## **DEPARTMENT OF PUBLIC WORKS**

**RE:** SP-19-00002  
Rampart Row

Public Works has reviewed the application supporting the request for SP-19-00002 (Rampart Row). Review comments appear below for your consideration.

RAMPART ROW SHORT PLAT APPLICATION

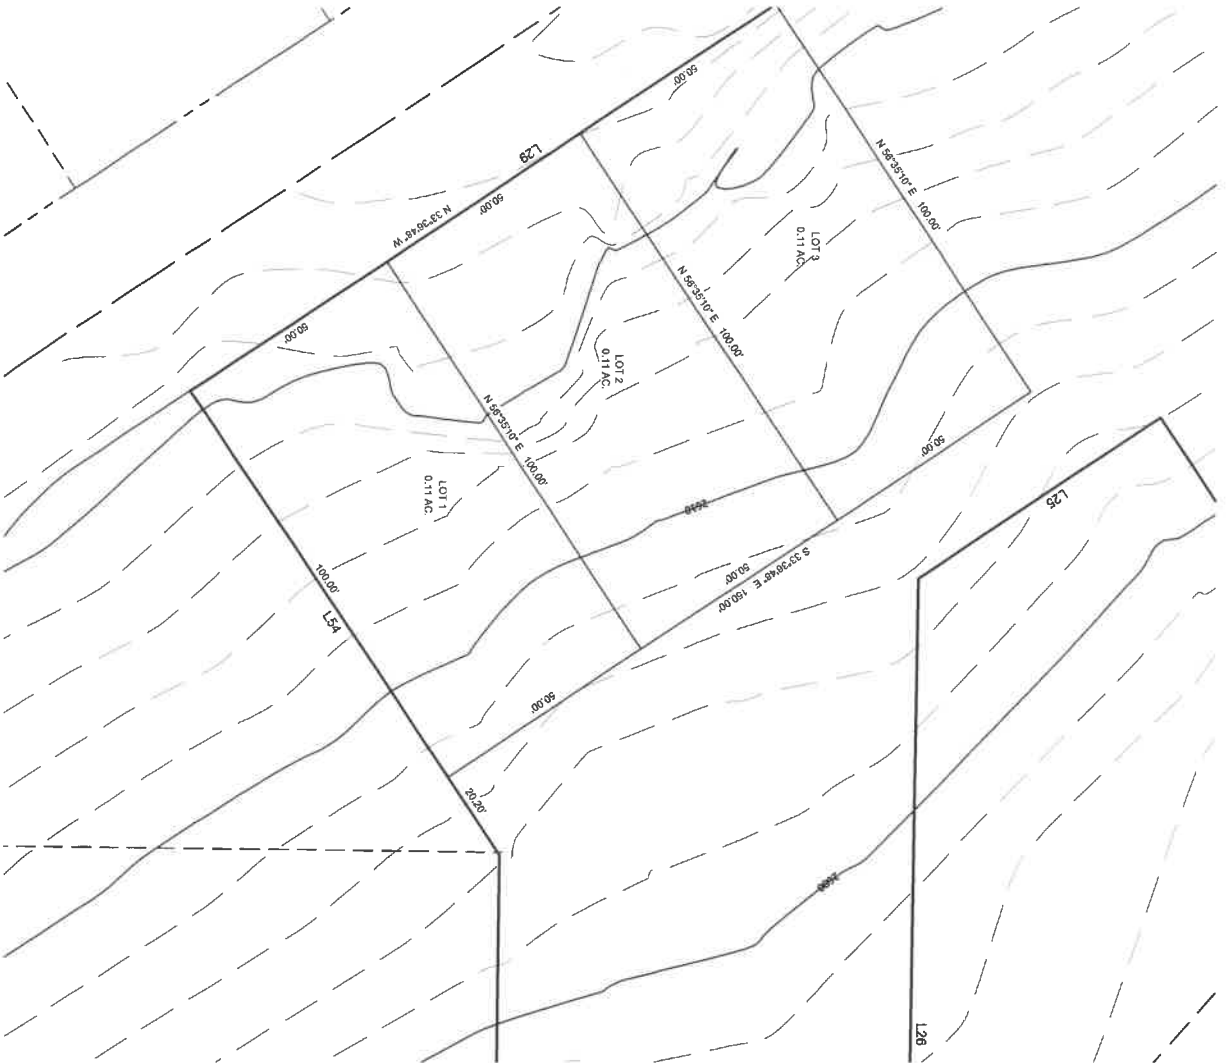
1. Address the new requirements of WAC 332-130-145.
2. The two labels for Lot 4 should be labeled as “part of” or “portion of”, so as not to appear to be two separate Lots.
3. The Parking Lot Easement should clarify if it is existing, dedicated, or to be created via separate document.

While not required for the preliminary, it appears that there appears to be a trespass, encroachment, or usage outside of the easement near the line labeled as L33. This should be identified on the final.
